Objection to Planning Application - 3/2026/0172 – Proposed erection of a detached dwelling with single garage and store – Land to rear of Pimlico House, Gisburn Road, Gisburn BB7 4ES

PROPOSED PLANS AND ELEVATIONS OF DWELLING					
Site: Pimlico House Gisburn Road Gisburn BB7 4ES					
Client: Richard Wilson					
Date: 18.02.26		Scale: 1:100 @ A2			
Project No: WILS/01 Dwg 01B			Drawn: DS		
Amendments:		A	B

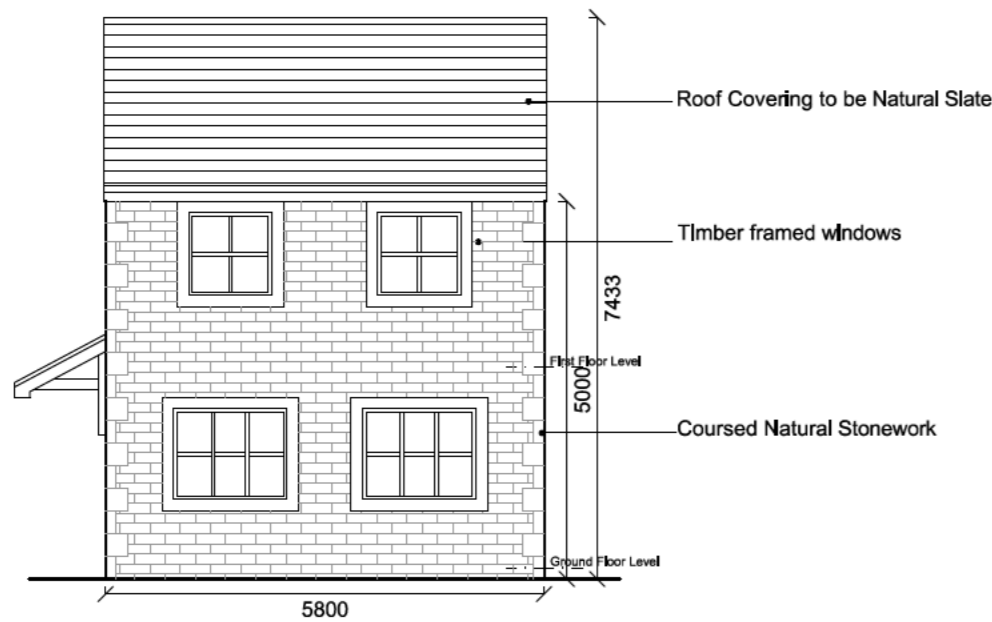
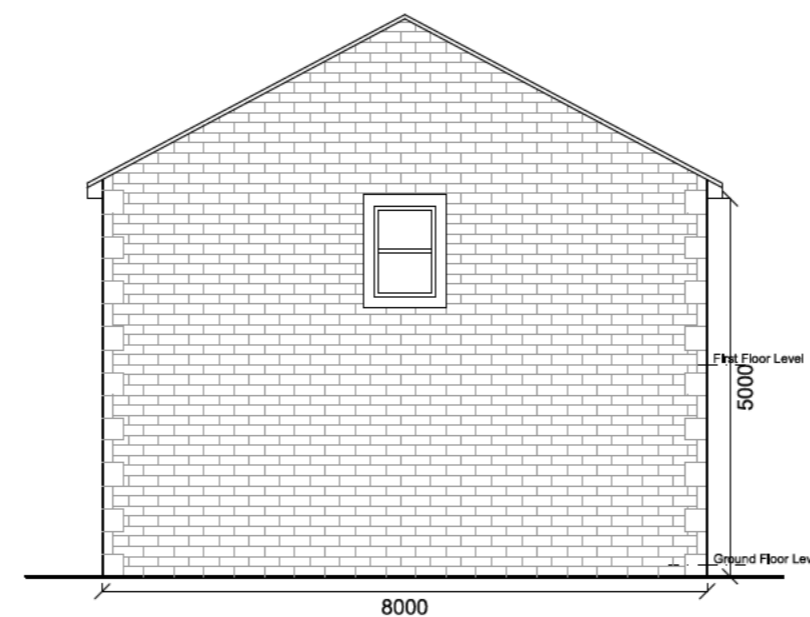
Previously, when Duckworth's had a building on the site it was a single storey building. This proposal is for a two storey property. The proposed property will take light [redacted] and [redacted] areas of [redacted] and will remove [redacted] and [redacted]. There will be an impact [redacted] which we have not had previously. We have never [redacted] to the [redacted] and in fact, chose this property for that very reason. This would therefore represent a loss of amenity for us.

We have always enjoyed a light and open countryside view from [redacted] as previously there was only [redacted]. What is being proposed [redacted] of a [redacted] which [redacted] will be particularly imposing. This removes the amenity of [redacted]. There has never been a two storey building on this site. The proximity of this [redacted] obvious concern to us. This new proposal now also includes a door and window in the gable end which [redacted]. This will remove privacy to the [redacted]. A drive and garage immediately on the other side of our [redacted] will bring unnecessary noise and disturbance [redacted] and [redacted] and [redacted]. Coming out of [redacted] [redacted] which has not existed before [redacted] and [redacted] and blocking our [redacted] views causes a loss of the amenities of peace, quiet and privacy.

The proposed street elevation on the plans appears to be stretched and gives the impression of space around this building – I don't believe that is the case. Mr Wilsons proposal says that this

application will allow sight into the conservation area of Pimlico House and surrounds, but in reality, most of the view will be blocked by the 2 storey house. Where the garage is proposed there is no view of Pimlico House so nothing has been gained (only that I will have [REDACTED])
